**MANSTON AIRPORT DEVELOPMENT CONSENT ORDER EXAMINATION
SUBMISSION TO DEADLINE 9:
Comments on Information requested by the ExA and received from the
Applicant to Deadline 8
and
Further Comments on Revised Noise Mitigation Plan [REP8-004]
and
Comment on Ns4.1
And
New Requirement 9b
And
Paragraphs 7.12 and 7.13 of [REP8-004]
and
Comment on F.4.2**

MANSTON AIRPORT DEVELOPMENT CONSENT ORDER EXAMINATION

Figure 12.6
Aircraft noise - daytime $L_{Aeq,16hr}$
contours - year of forecast maximum
capacity

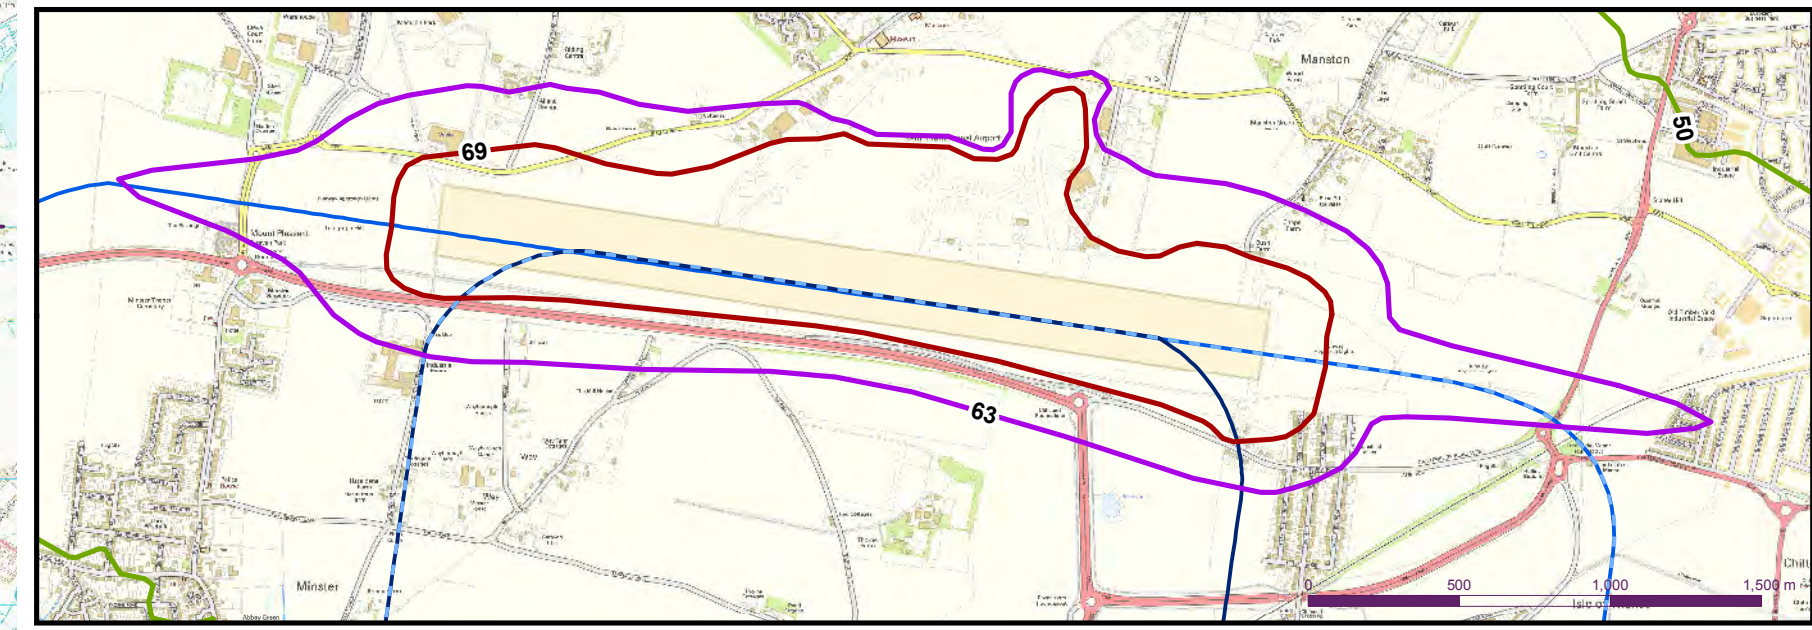
7.4. Given that the LAeq 16hr noise contours produced by the Applicant in its Environmental Statement show only three noise contours at 50dB, 63dB and 69dB⁴, it is impossible for any Interested or Affected Parties in the local area to identify whether they fall in any other noise contour - including, for example, 57dB or the 60dB contour. Indeed, the Applicant’s noise contours give the somewhat misleading impression that everyone outside the 63dB contour falls under a 50dB noise contour.
